Recommendation Report for Planning Permission

REF NO: LU/243/17/PL

LOCATION: 56-57 Pier Road
Littlehampton

PROPOSAL: Conversion & minor extension of existing restaurant & five bedroom flat to create a shop unit & 6 No. residential units (resubmission following LU/71/17/PL).

Drawing Title
Proposed Drawing
Lower and Upper Ground Floor Plans
1/100 @ A3

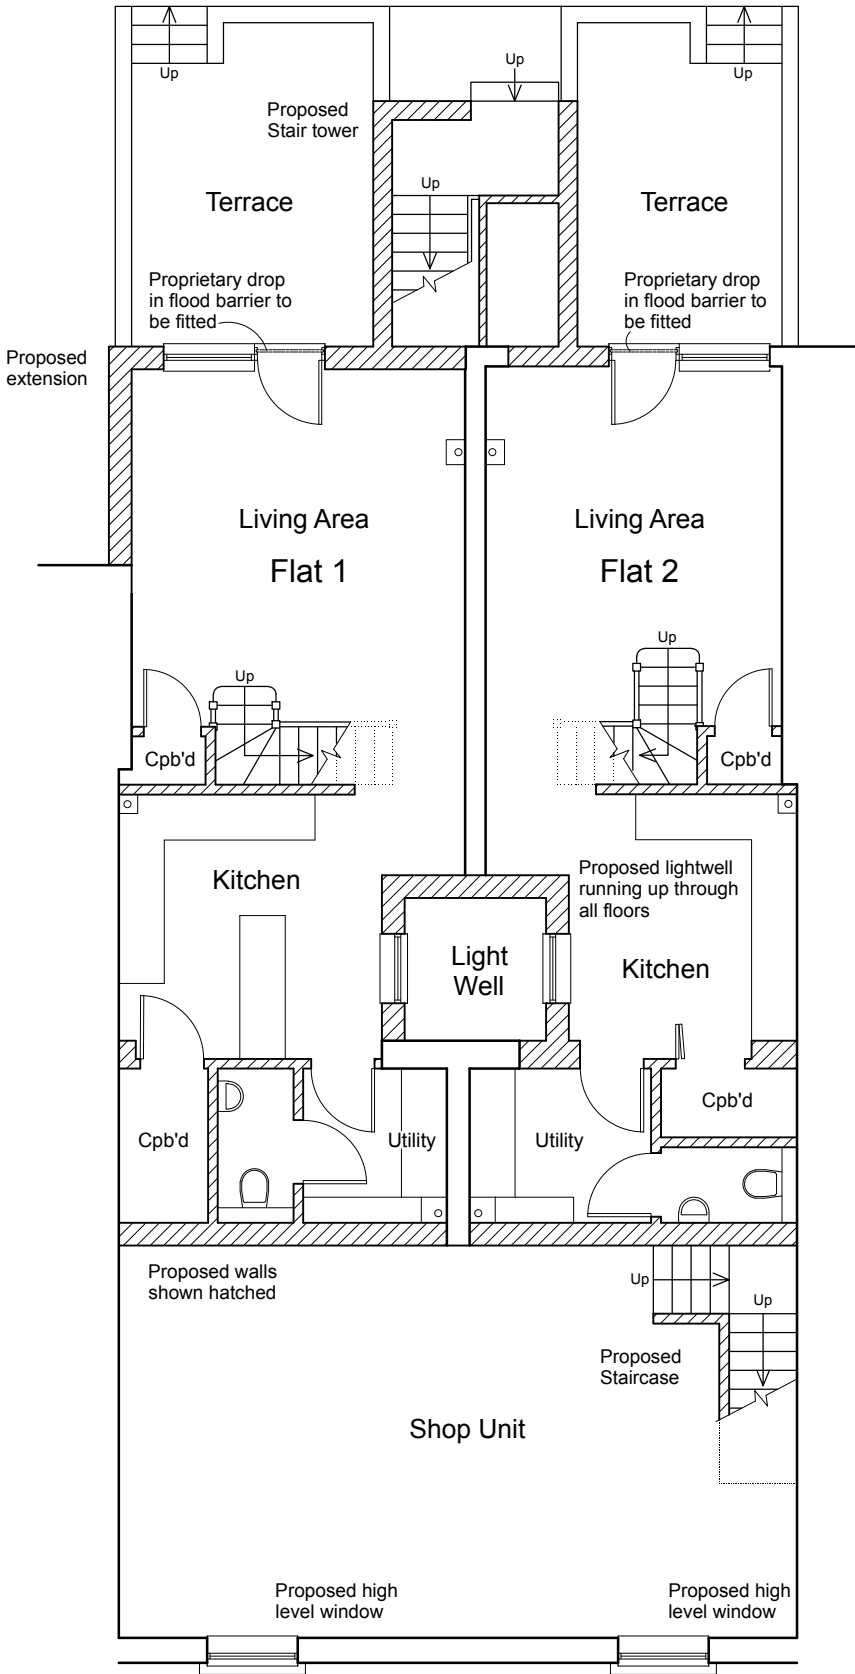
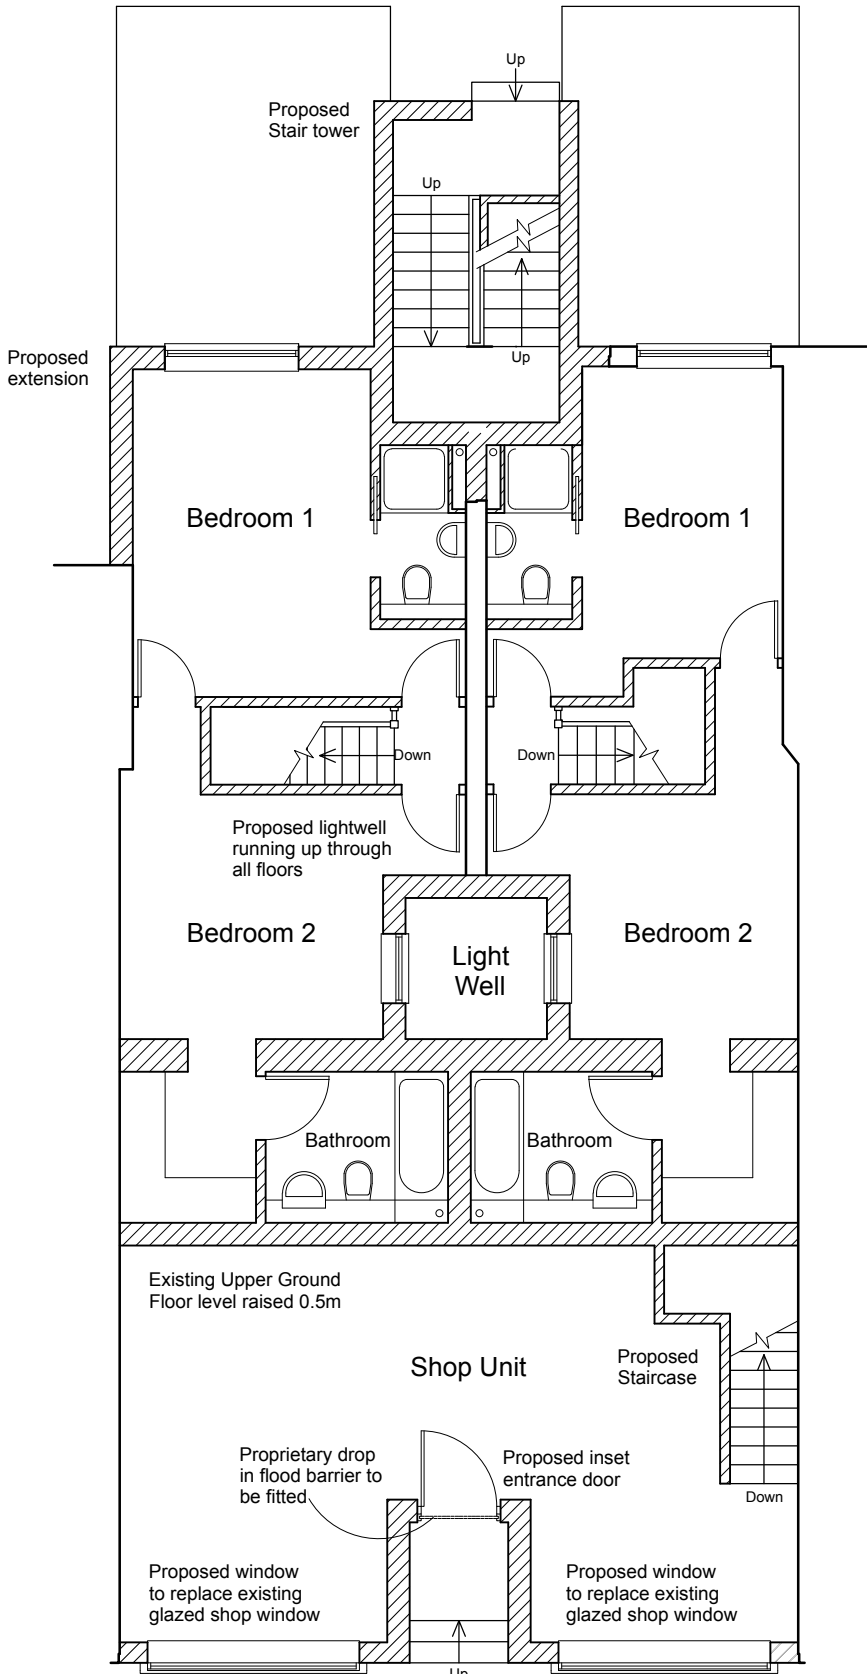
room. The escape routes to all the flats is via the kitchen, this can be overcome in bedroom 1 of the upper ground floor and first floor by ensuring that the window in the bedroom is an escape window and adequate fire protection within the flat. However, due to the nature of the building being terraced this is not going to be possible in bedroom 2 of both flats on the upper ground floor and an escape window is not acceptable at second floor level therefore these flats must be redesigned to ensure adequate fire precautions. There should be adequate fire separation between the commercial unit on the ground floor and the residential flats above.

- The provision of natural ventilation and lighting to the bedrooms via a light well is not ideal, and a lack of view/aspect can be detrimental, therefore an alternative layout is recommended.

For the proposals to be acceptable it would need to preclude habitable rooms at basement and ground floor level. Development (particularly bedrooms) would need to have a finished floor level set above the 1 in 200year undefended level plus an allowance for climate change of 4.94mAOD.

Basements would only really be suitable for storage/ancillary purposes (as previous use). Ground floor levels could be used for habitable if internal tanking could be installed to the 1 in 200 year plus climate change undefended level of 4.94mAOD, subject to the 'Communities In Practice Guidelines', suitable safe egress and access and Building Control approval.

Note that the proposal includes installing lights, at and below footpath level, into the 'lower ground floor' which on one drawing is described as a basement and/or store - there may also be headroom issues here, as I cannot see what the existing headroom is from an existing section - is the floor of the 'lower ground floor' staying as existing basement or might there be a wish to extend down to gain headroom, in which care will need to be taken in carrying this out.

The proposal is considered to conflict with relevant Development Plan policies in that the provision of residential units at ground floor and basement level would result in an unacceptable risk of flooding.
